DRB Project Number: 2021-006308  
Wyoming and Alameda

SUBJECT: Preliminary Plat

DRB Project Number: 2021-006308 Hearing Date: 09-13-2023  
Project: Lots 1 – 3, La Cueva Views Agenda Item No: 2

**PR-2021-006308 / SD-2023-00159 (Wyoming Blvd between Alameda & Signal)**

SHEET 3 OF 4

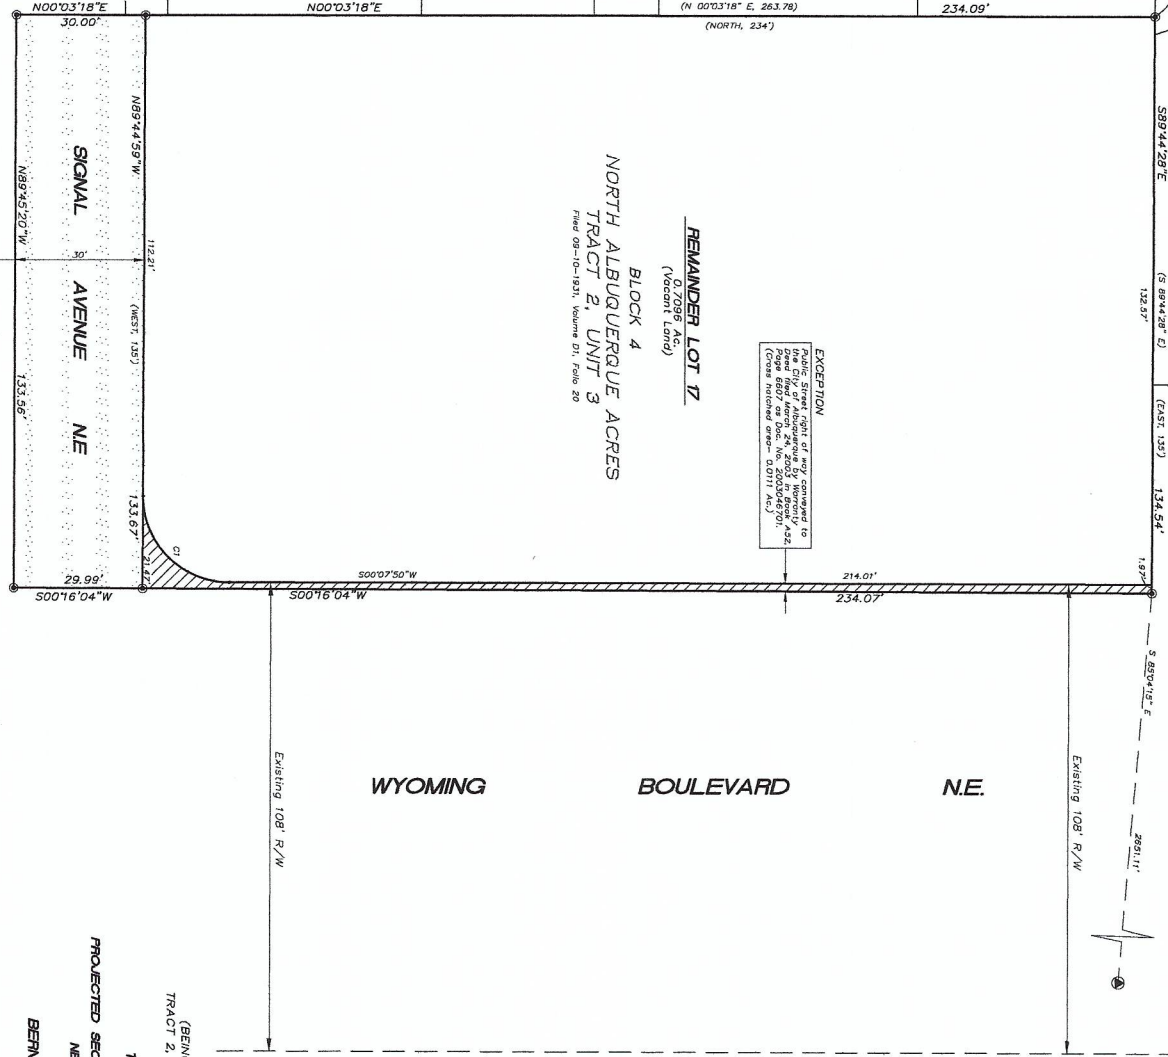
1. Wyoming is a Principal Arterial, please confirm that there is an existing 6' sidewalk and 5-6' landscape buffer along the frontage.

- **\*Please confirm ROW development detail and the compliance of section 7 of the DPM, Table 7.2.29. In regards to Sidewalk width requirements and its landscape buffer.**
